Arun District Council Planning Department
Arun Civic Centre
Maltravers Road
Littlehampton, BN17 5LF

RE YOUR REF: AB/39/19/PL
SIAN EGGINGTON

Development Application for Change of Use from Financial and Professional Services (class A2) to mixed use: Retail (Class A1) and staff offices.
Location 55-57 High Street Arundel

SURVEY - GROUND FLOOR PLAN

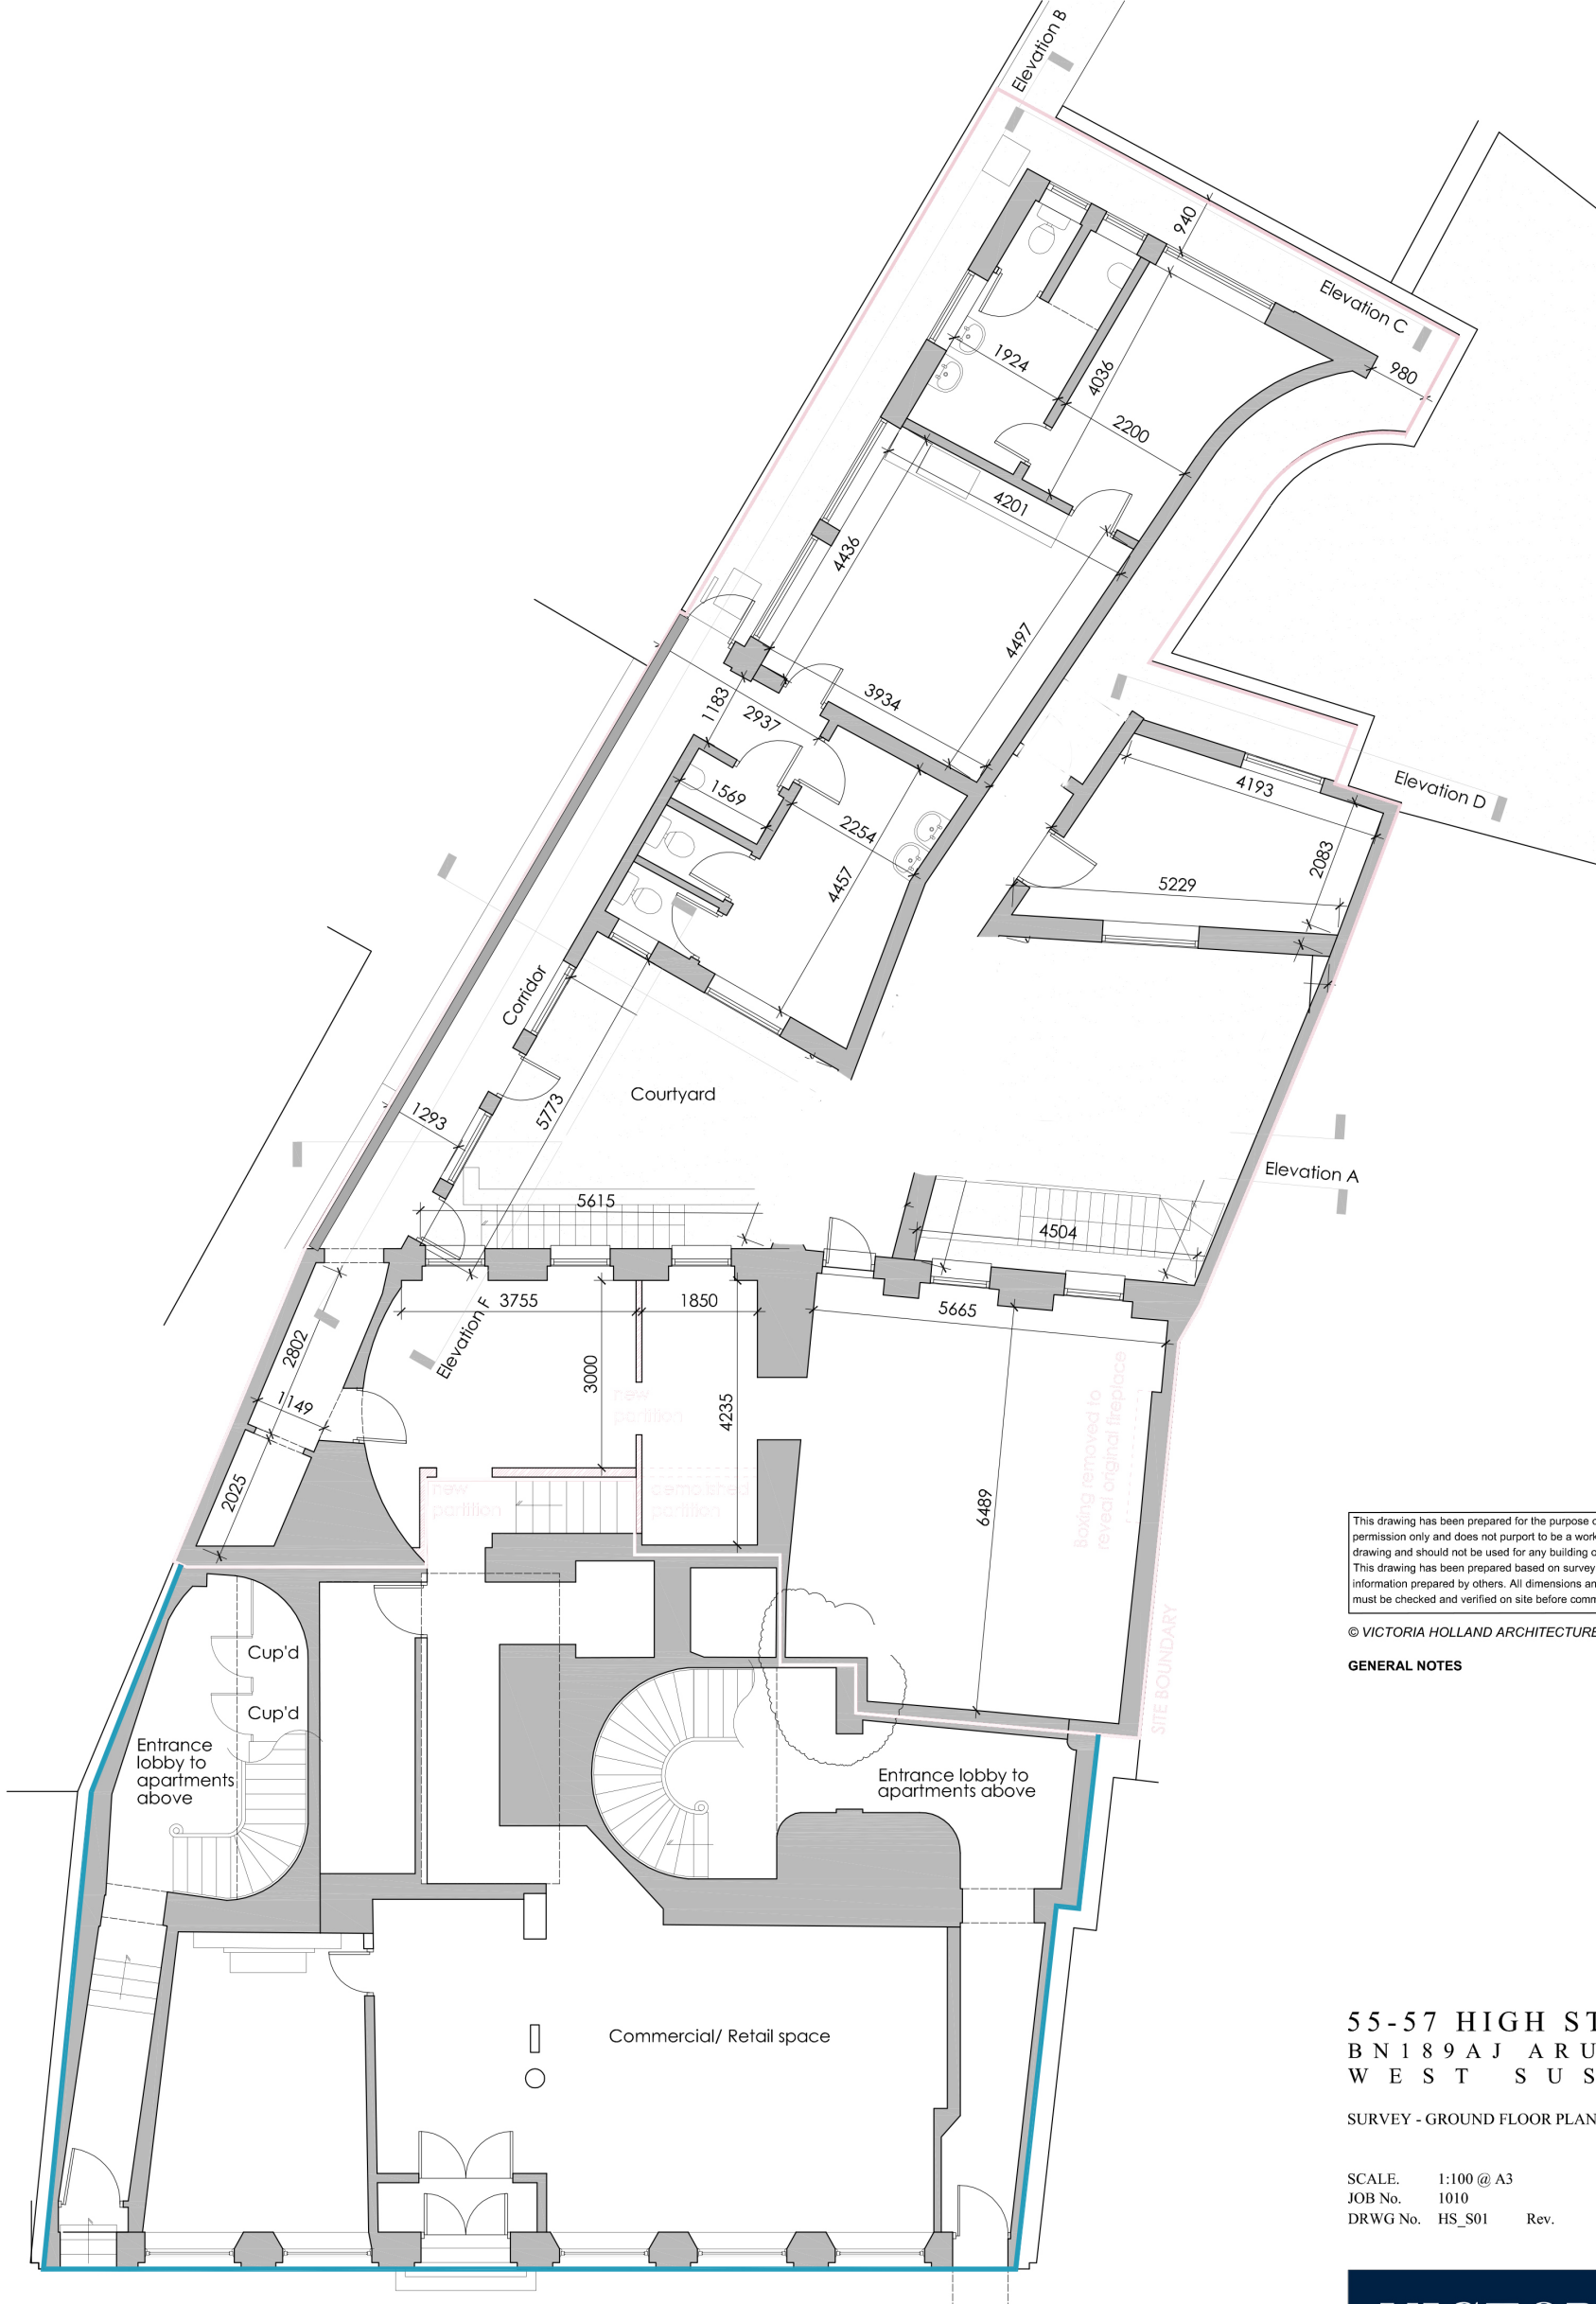
Existing Floor Plan: Please provide the existing floor plan with room labels to clearly illustrate the change of use.

- Demolition: yes, please go ahead and remove this section from the form as we are not touching the layout in anyway – thank you.
- Existing Floor Plan:
 - You had requested that we label the use of each room. I have done so in the attached floor plan, with all additional information to you in red text. I have also put a pinkish bounding box around what in my mind is the 'retail space', ie the space into which the public enter to experience our retail offering, and thus excluding the supporting office and staff spaces. Is that helpful? Does that perhaps simplify our request? I appreciate that the planning history on this property on this building is a little complex and so appreciate your guidance.
